PLANNING APPLICATION CONSULTATION RESPONSE

Application Number:	3/2024/0389
Proposal:	Approval of details reserved by conditions 8 (tree and hedgerow protection), 9 (construction traffic management plan), 14 (surface water drainage strategy), 15 (construction SW management plan), 16 (SW drainage operation and maintenance manual), 17 (SW verification report) and 20 (Phase 2 land contamination report) of planning permission 3/2021/1262.
Location:	Land at the North of the Chapel Hill site Longridge

Lead Local Flood Authority Position

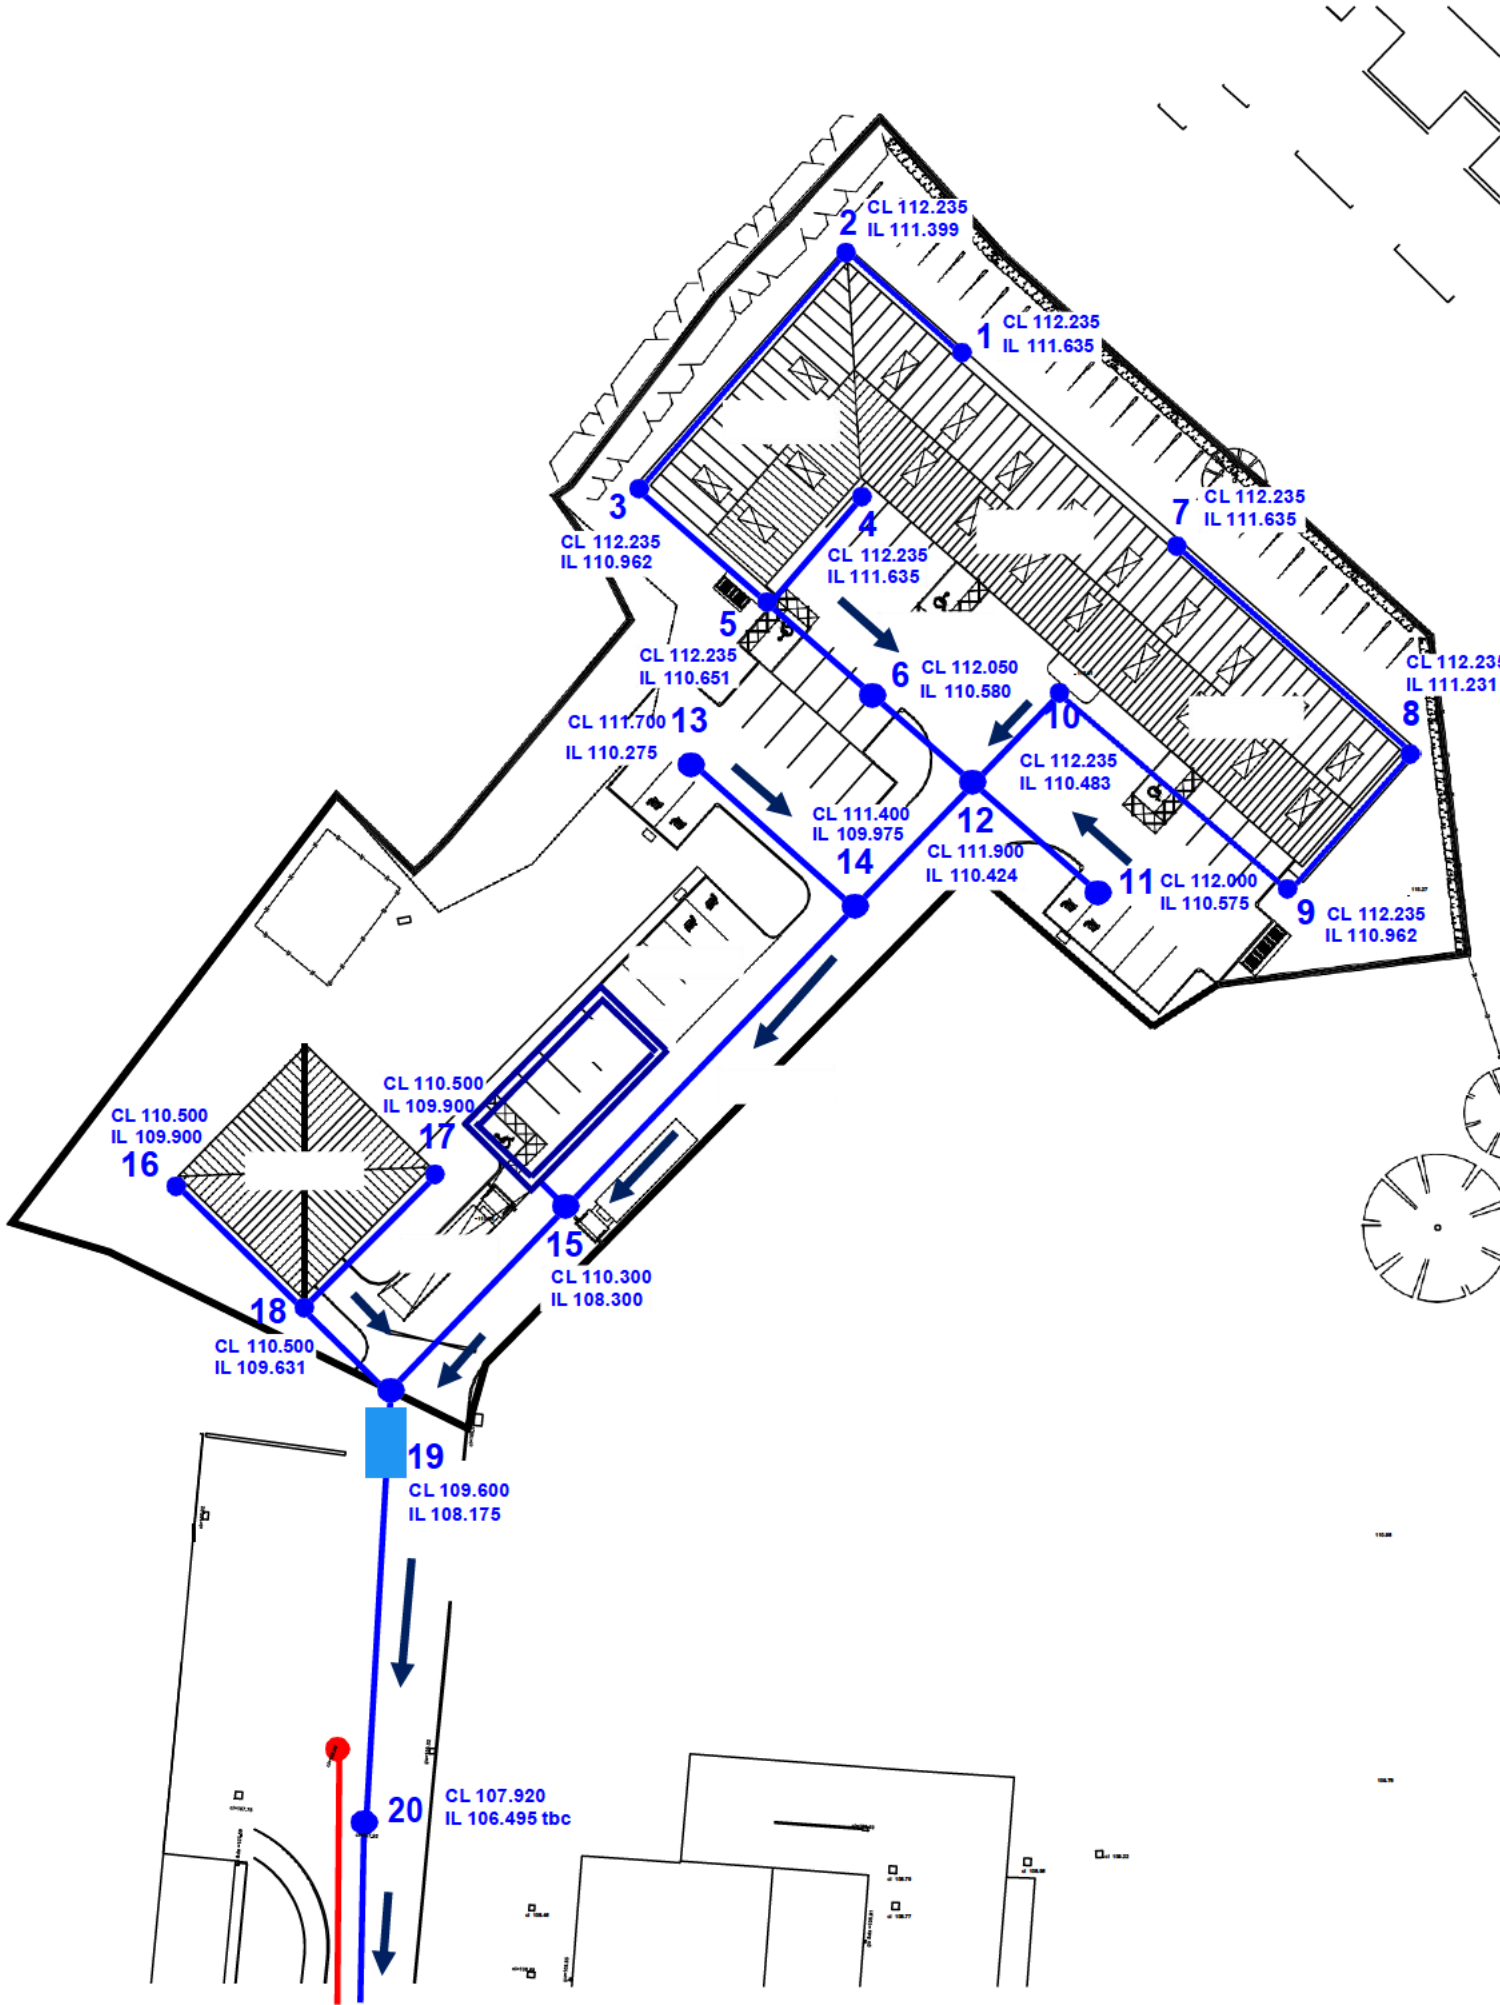
- The applicant has failed to provide Finished Floor Levels (FFL) in AOD to confirm minimum 150 mm+ difference for FFL with adjacent ground levels. This information is not present on the drainage layout within the cover letter provided by the applicant.

EXCEEDANCE FLOW

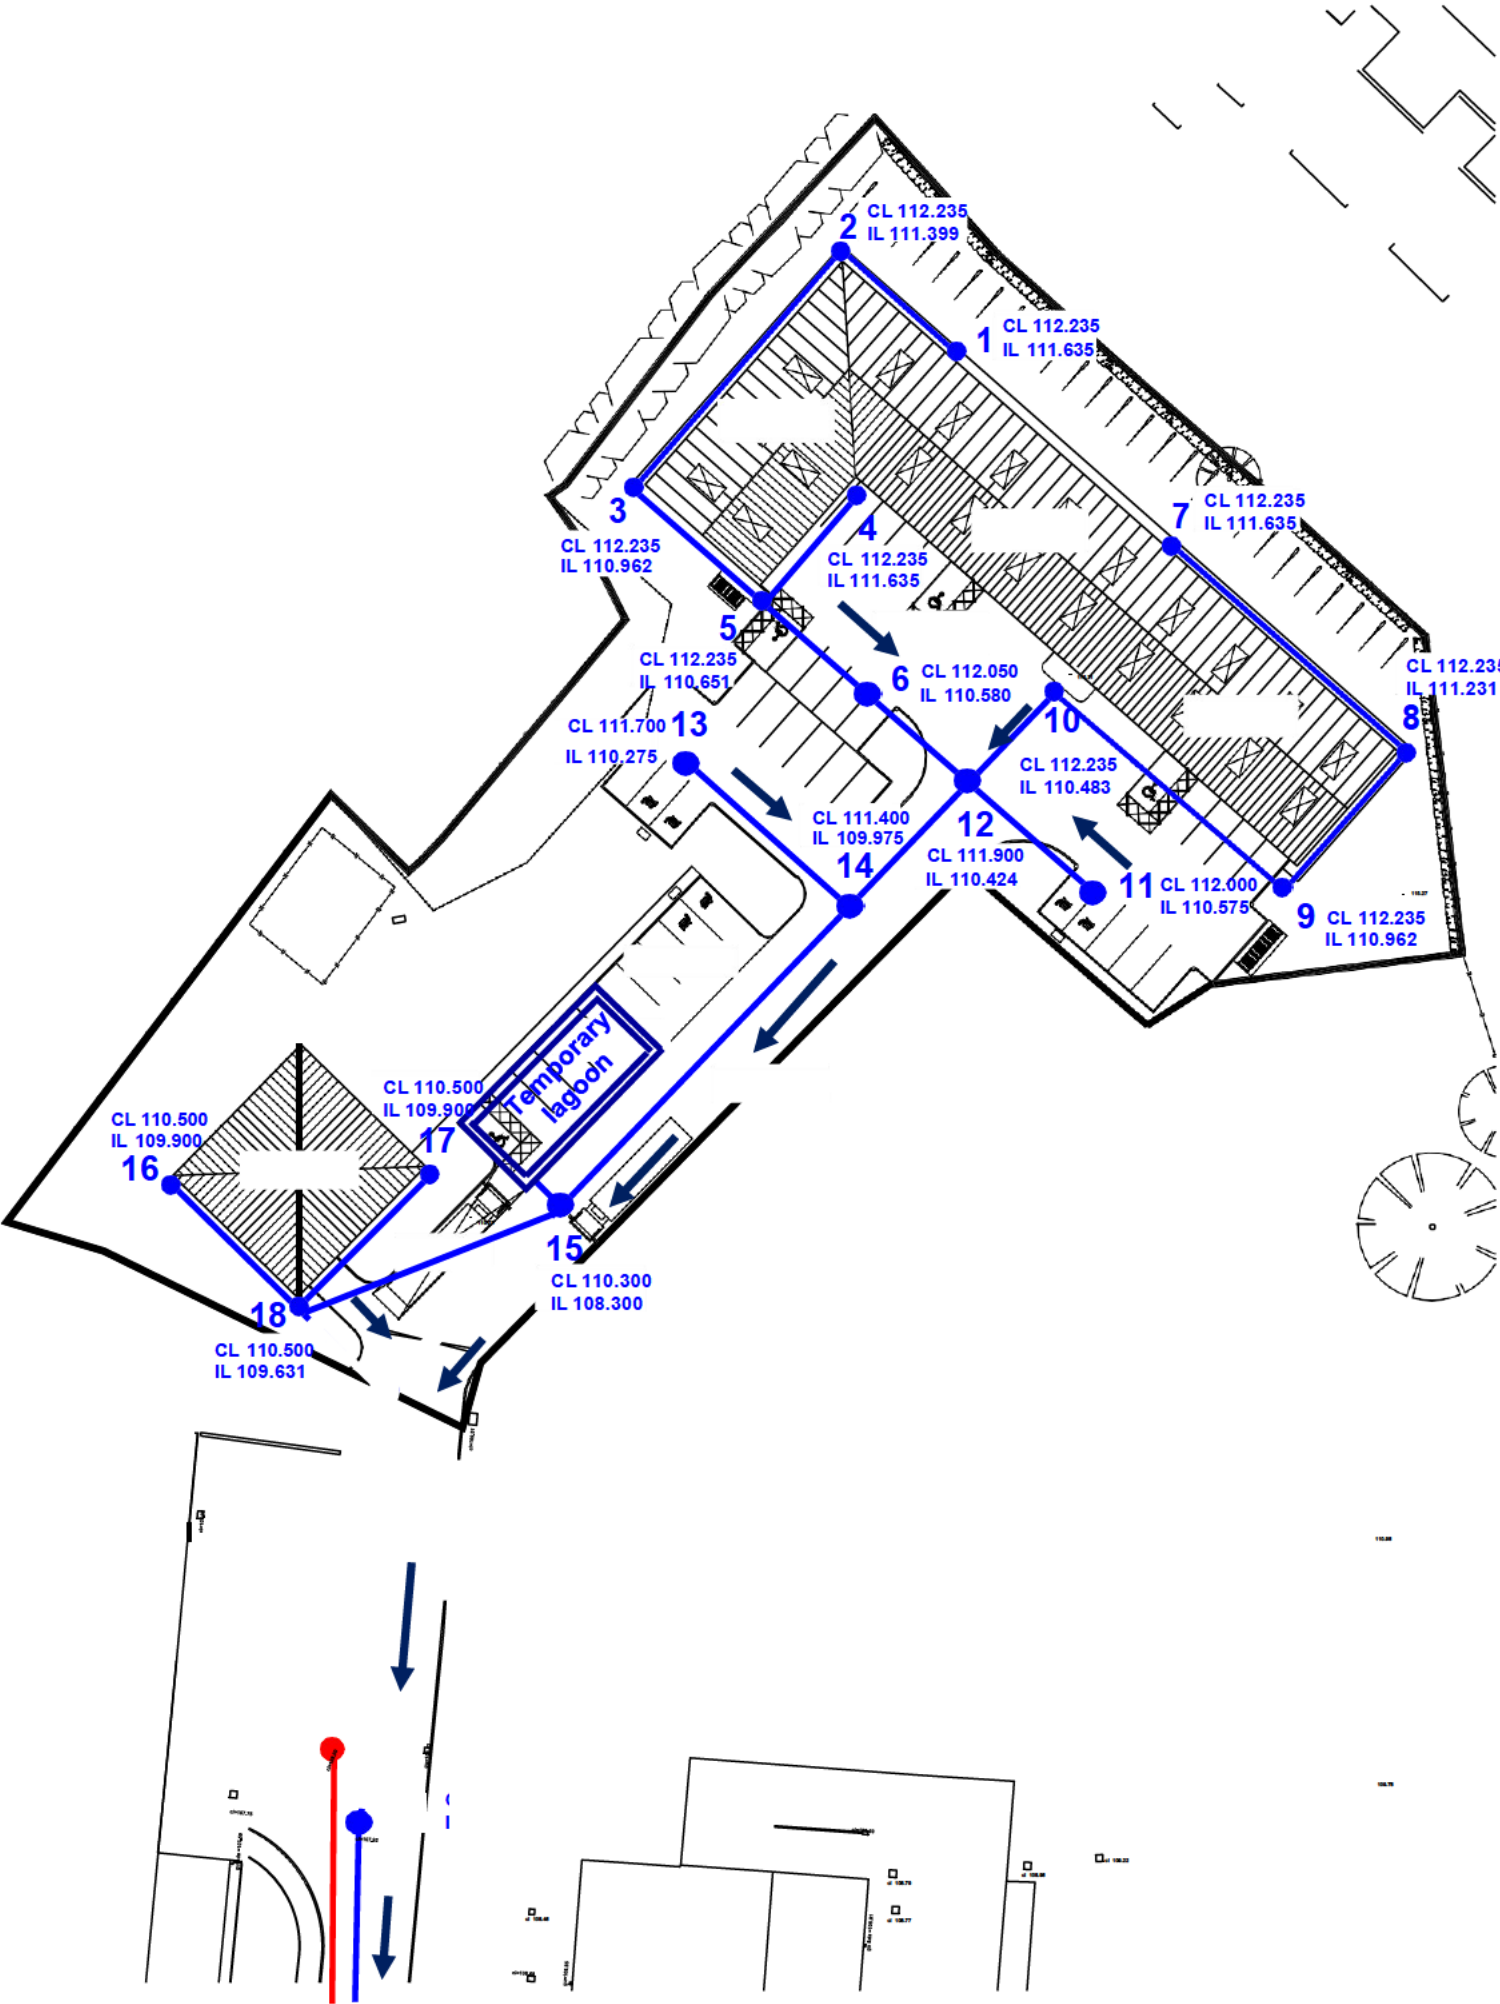
- The applicant has failed to provide details of drawings showing topography and slope gradient as appropriate, the importance of this information is to ensure that the proposed topography of the development will not propose a risk to people and property in a flood exceedance event. The provided flood exceedance plan shows the indicative flow based on cover levels, this does not correspond with any proposed topography, as well as providing clear evidence that the any proposed raising of levels from the existing topography to the proposed will not result in the diversion of surface water it may not have previously conveyed to and therefore increasing the flood risk onsite or elsewhere.
